Response to Submissions

Prepared for: **Grand Noble Project 1 Pty Ltd**

The State Significant Development Application (SSD-96272465) for residential development with in-fill affordable housing at 11–23 Rangers Avenue, Mosman was publicly exhibited between 4 December 2025 and 17 December 2025. During the exhibition period, a total of 185 submissions were received.

DEEP SOIL

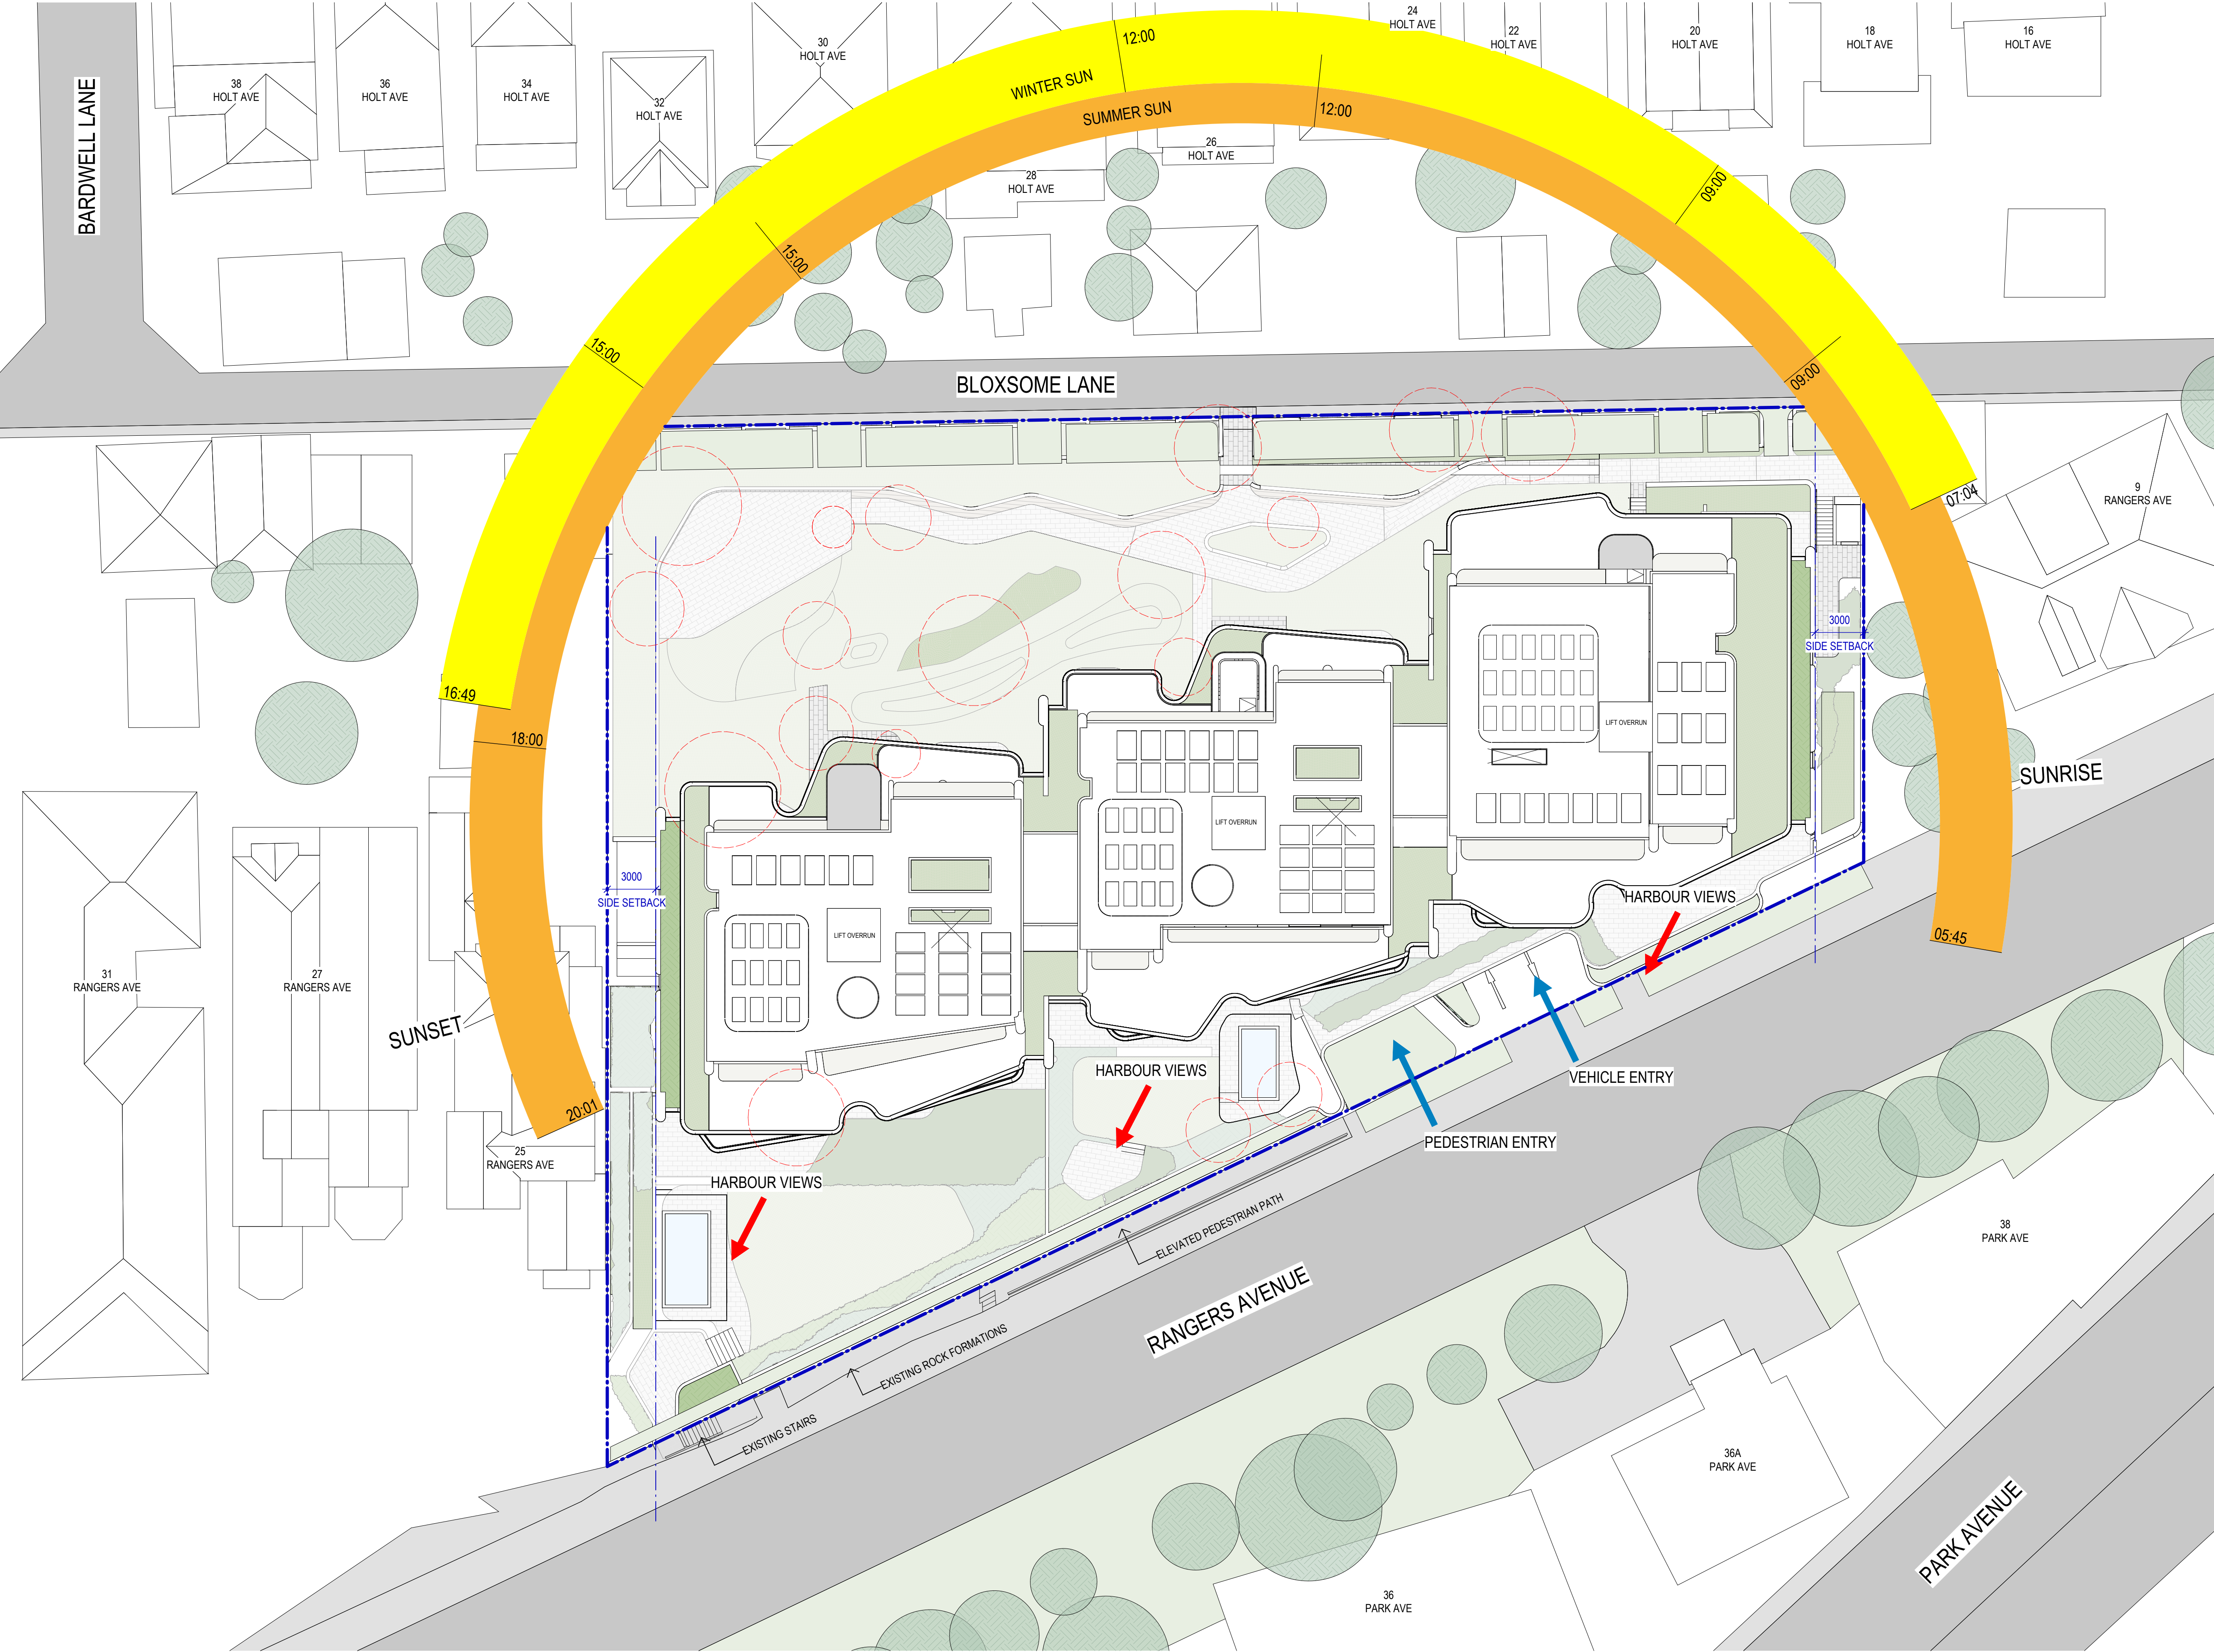
- Raises landscaping and tree canopy matters, including recalculation of deep soil per ADG definition, confirmation of 30% landscaped area, and additional planting/soil volume details.

- Raises concerns on deep soil and landscaping outcomes, disputing the applicant’s deep soil calculations and identifying a shortfall against minimum requirements, with limited deep soil along boundaries reducing the opportunity for meaningful canopy trees and screening (noting much landscape is podium planting).

1 Setback Diagram
SCALE 1 : 200

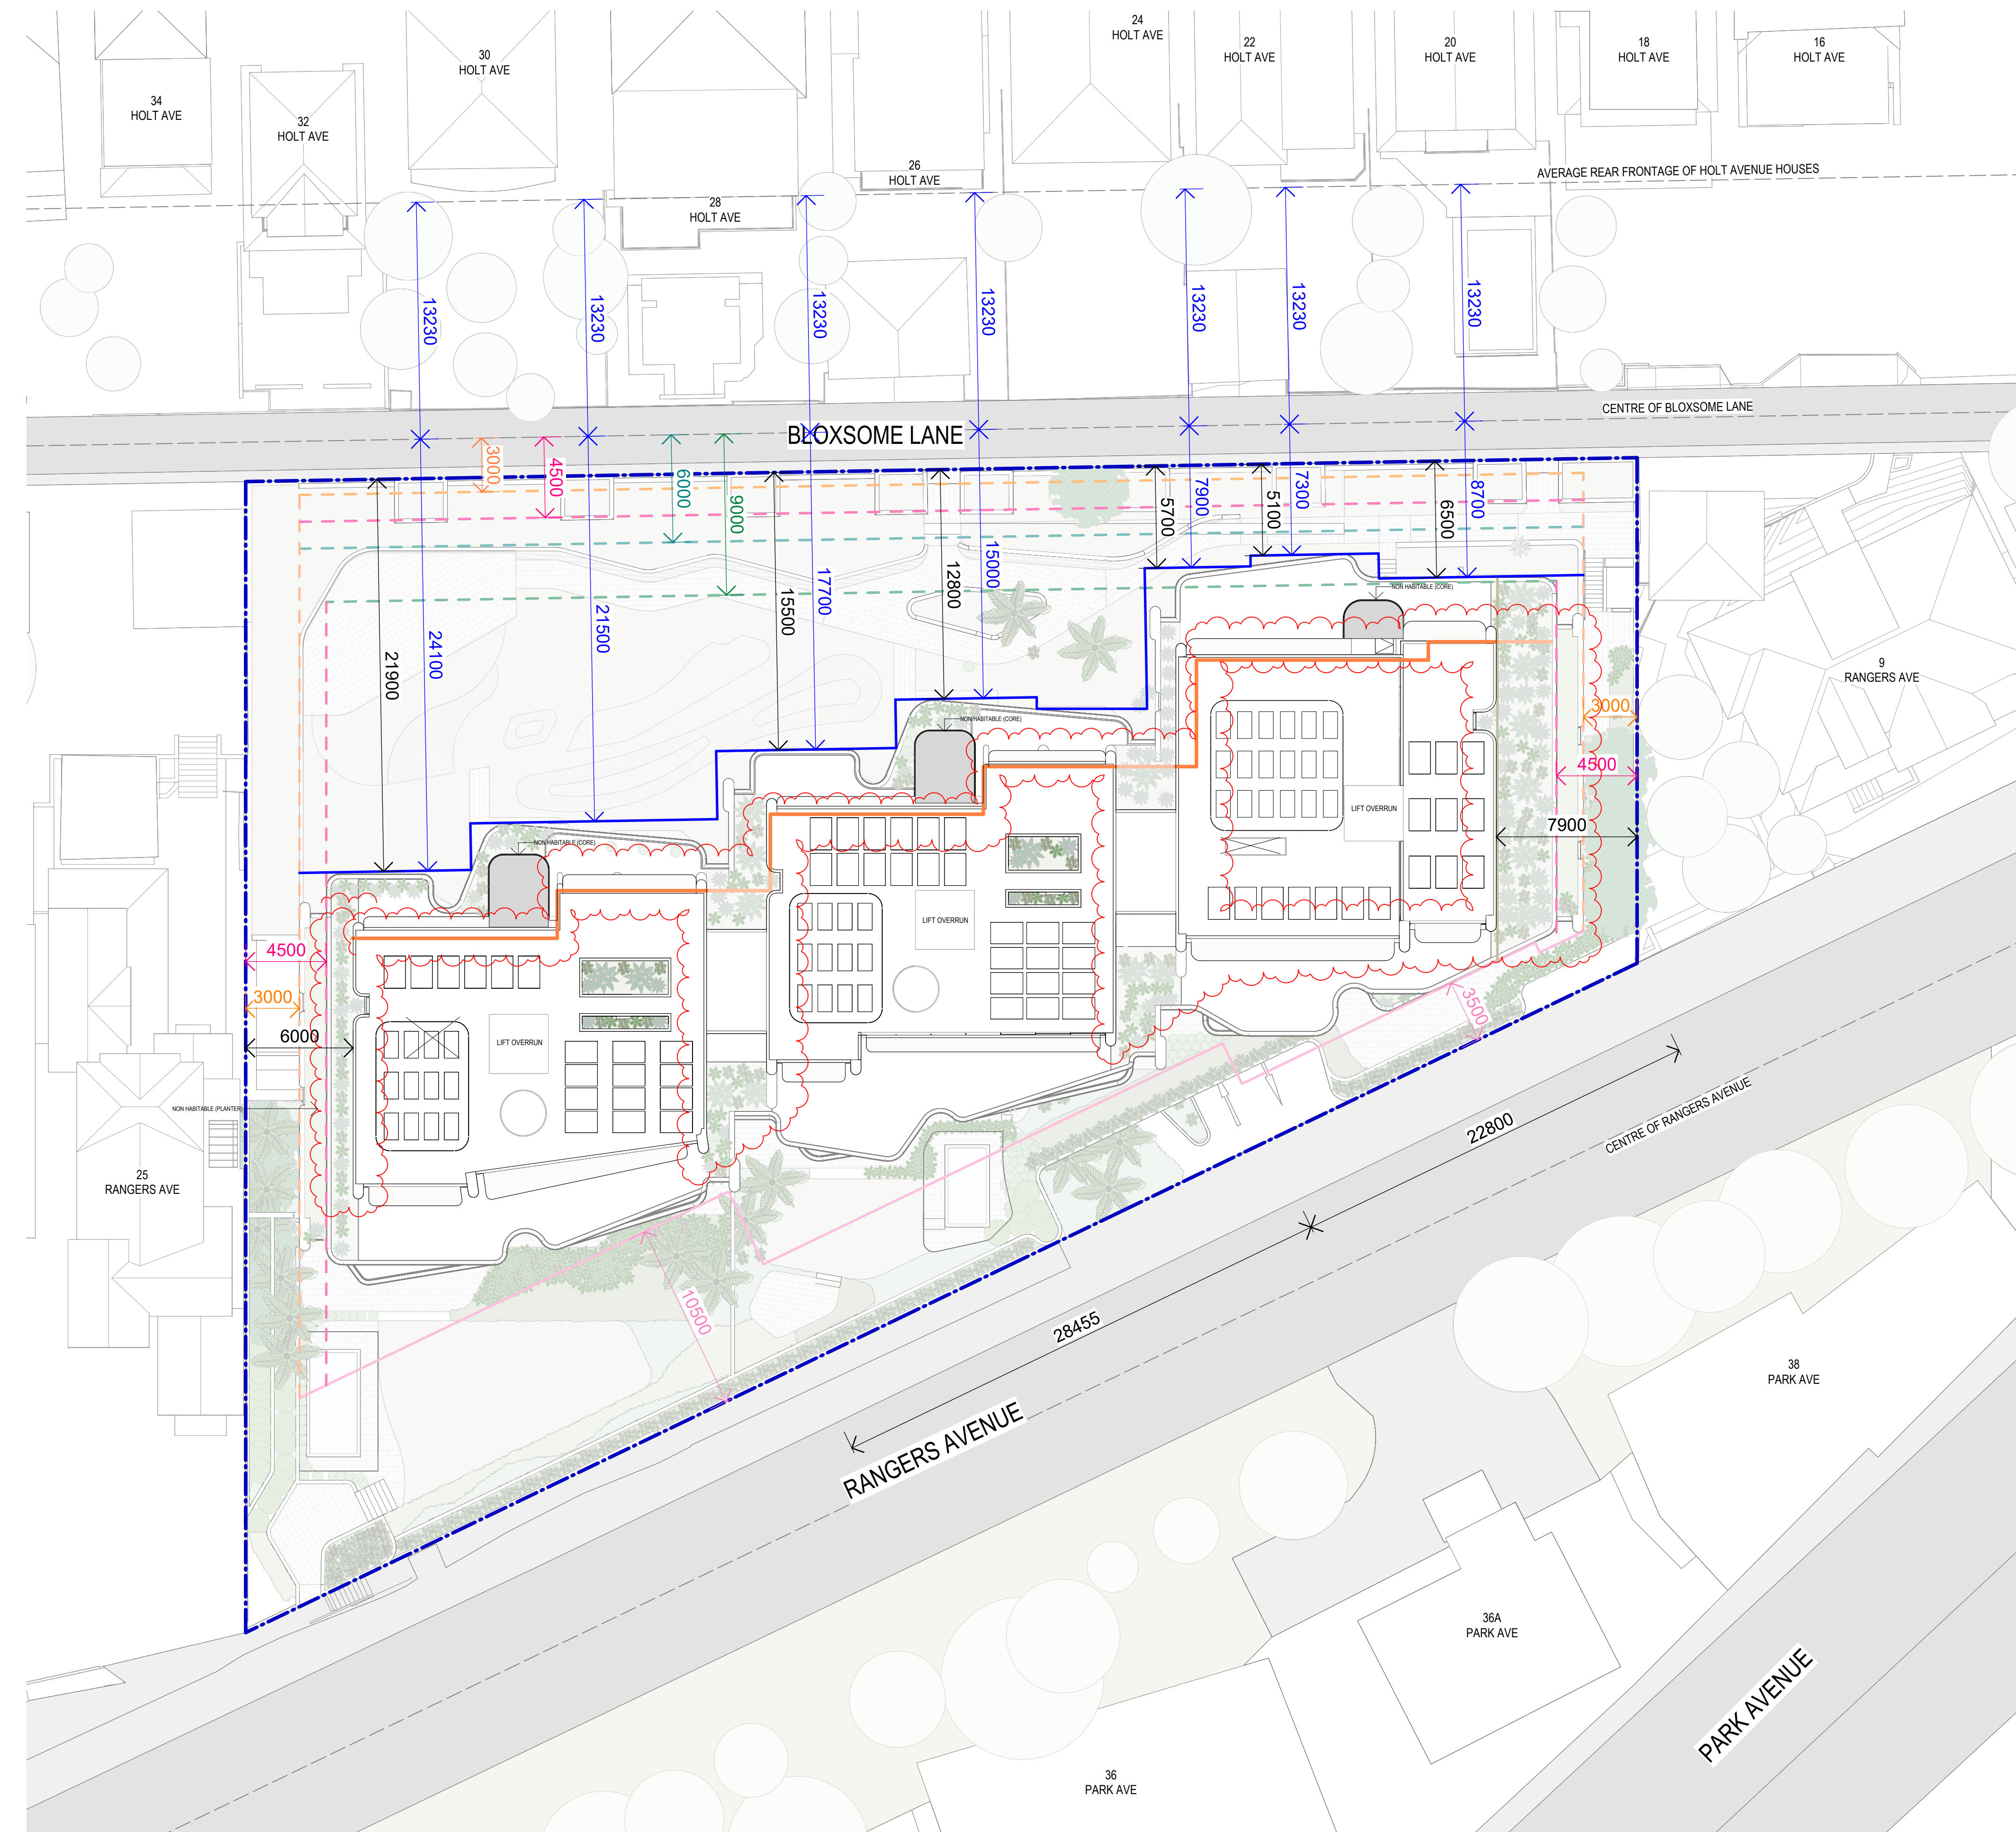
Public Authority	Position
DPHI	- Requests increased side setbacks and building separation to adjoining properties towards the east and west direction, to improve amenity outcomes and enable additional landscaping and deep soil area. - Raises concerns the proposed basement with zero setbacks and suggests a reduced car park basement footprint to increase setbacks and enable deep soil planting along the Bloxsome Lane boundary. - Identifies built form and character concerns, including dominant mass and limited façade articulation. Requests additional façade

- Raises concern on the proposal's proximity to the Holt Estate Heritage Conservation Area (**HCA**), noting the proposal's scale with a c70m long massing with only 3m setback to the east and west is an appalling outcome for the surrounding residential suburban character areas.
- Objects to insufficient deep soil and canopy planting along the northern boundary, stating the basement excavation runs hard up against Bloxsome Lane, leaving no capacity for deep-soil canopy trees to screen the development from the HCA.
